106 Brookmans Avenue
Brookmans Park
Hatfield
AL9 7QQ

29/09/2018

Re planning application ref 6/2018/1996/FULL
– proposed development at 77 Brookmans Avenue.

Proposed Refuse StorageDetails

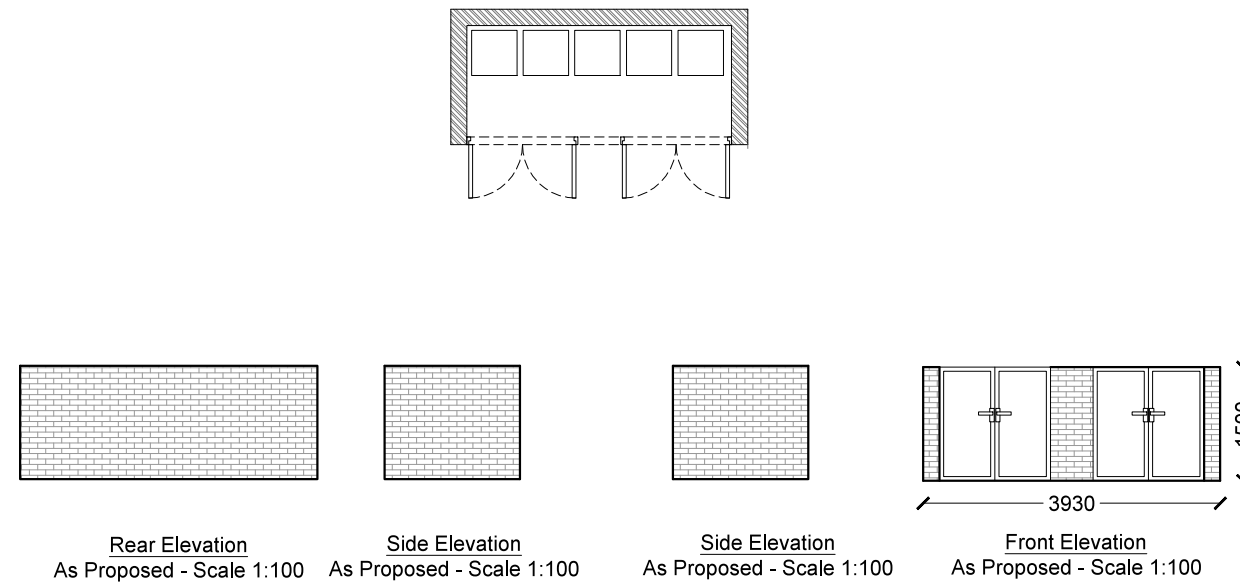
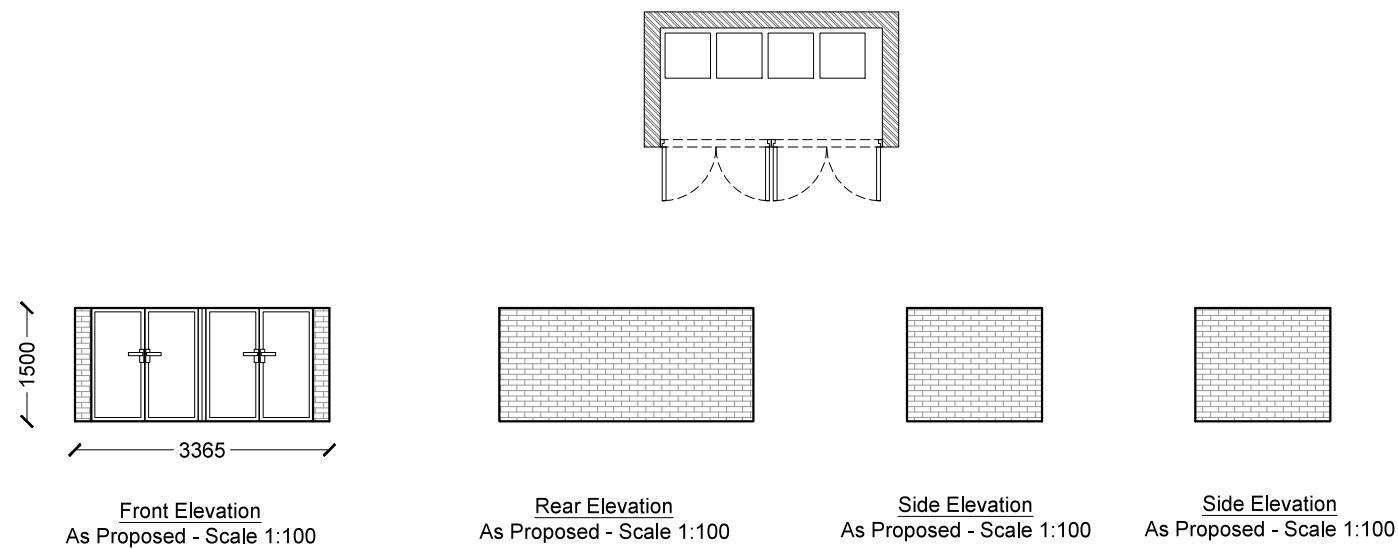
The proposal shows 8 storage areas, if these are for refuse bins, of which we have 3, one recycling, one garden waste, one household refuse, this would equate to 24 bins storing rubbish in close approximation causing an increase in the likelihood of vermin, as well as increase in kerbside obstruction when presenting for collection.
